SCOPING OPINION

Proposed Avon Power Station

March 2015

This is the Scoping Opinion (the Opinion) provided by the Secretary of State in respect of the content of the Environmental Statement for the proposed Avon Power Station at Severnside near Bristol.

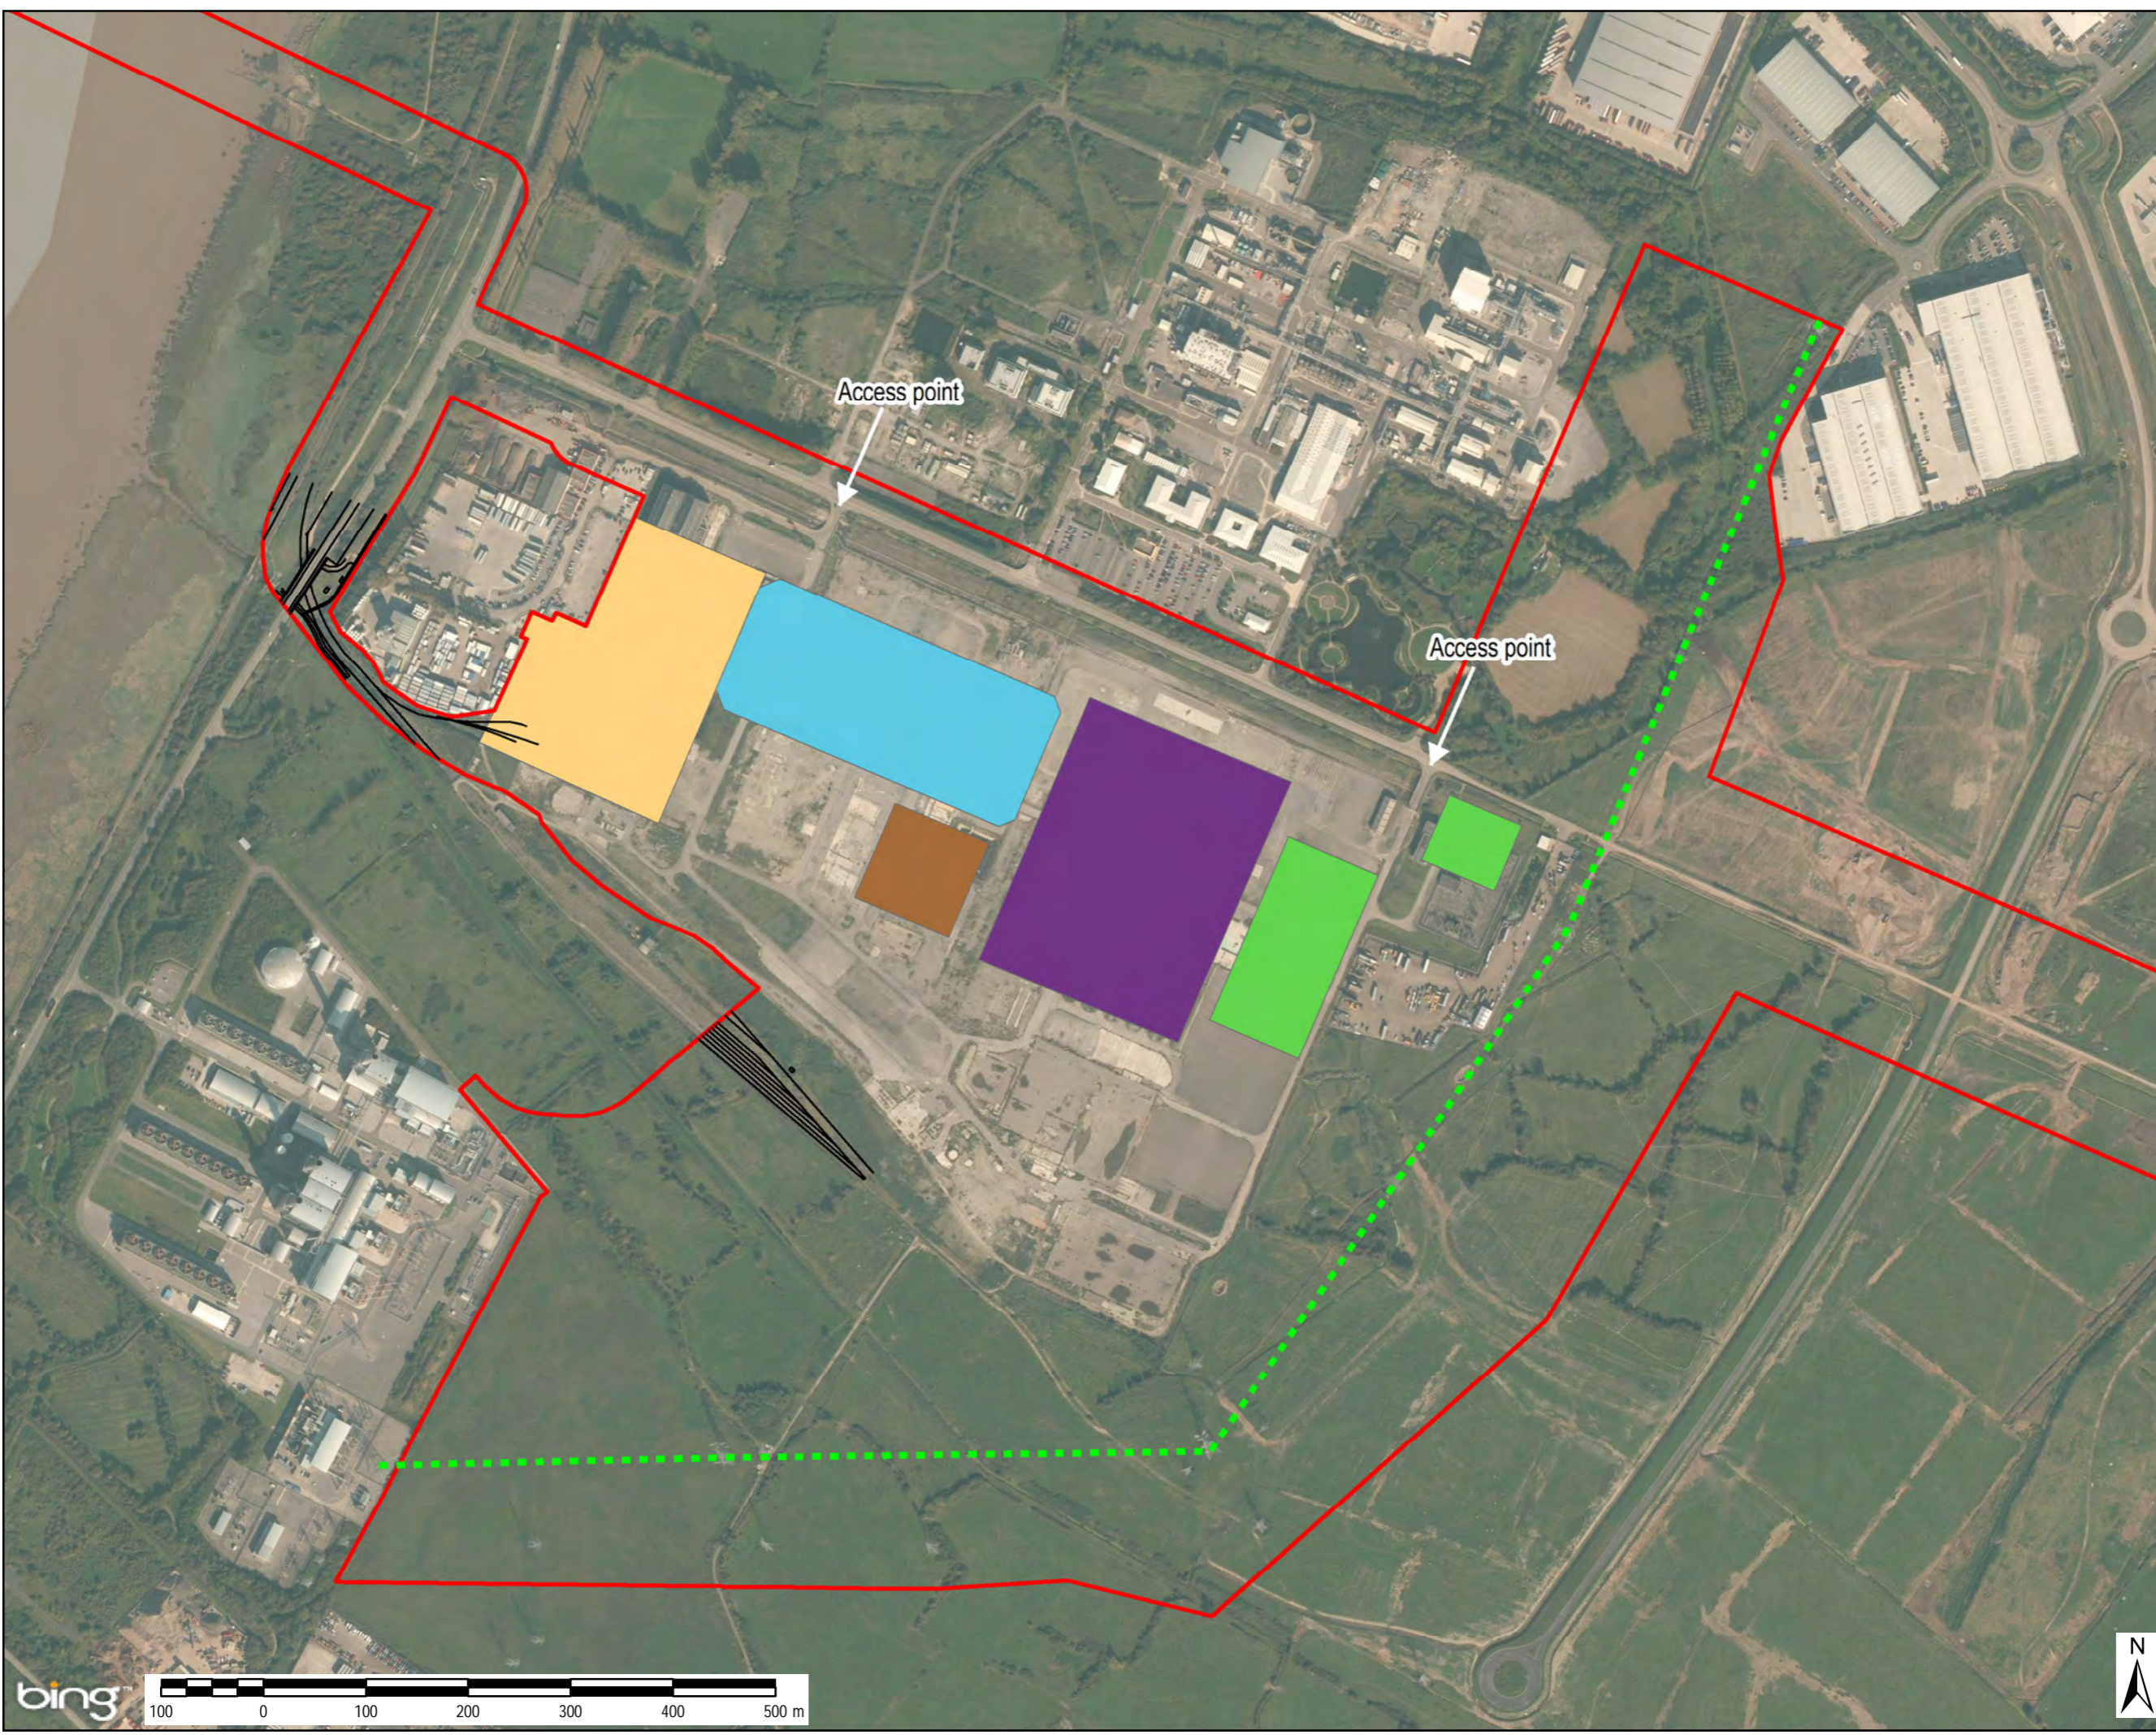
- 2.30 Paragraph 3.7 of the Scoping Report confirms that the proposed power station site would be accessed from two points on Central Avenue located to the north of the development site. The access points are illustrated on Figure 6 in the Scoping Report. The western access point is currently in use and provides access to the existing site office and car park on the site. The eastern access is currently gated and would require reinstatement.

- 2.32 Paragraph 3.31 of the Scoping Report confirms that there is the potential to re-establish the existing rail sidings on the site to facilitate the importation of construction material, particularly if infill is required to raise ground levels to mitigate flood risk. The location of the existing rail sidings is provided on Figure 6 in the Scoping Report.

- 2.35 Paragraph 3.42 of the Scoping Report confirms that details of the proposed construction activities and a phasing programme would be included in the ES. The location of the construction and laydown area is identified on Figure 6 of the Scoping Report.

- 2.60 Whilst the project description in Chapter 3 of the Scoping Report confirms that the power station site would be accessed from two points on Central Avenue to the north of the site, additional information is provided on a potential access point to the south of the site as a result of a proposed extension to an approved new link road. If the applicant intends to consider this as a viable access point, a description of this route and an assessment of this option should be provided in the ES. The ES should also identify the access points for the associated connection works.
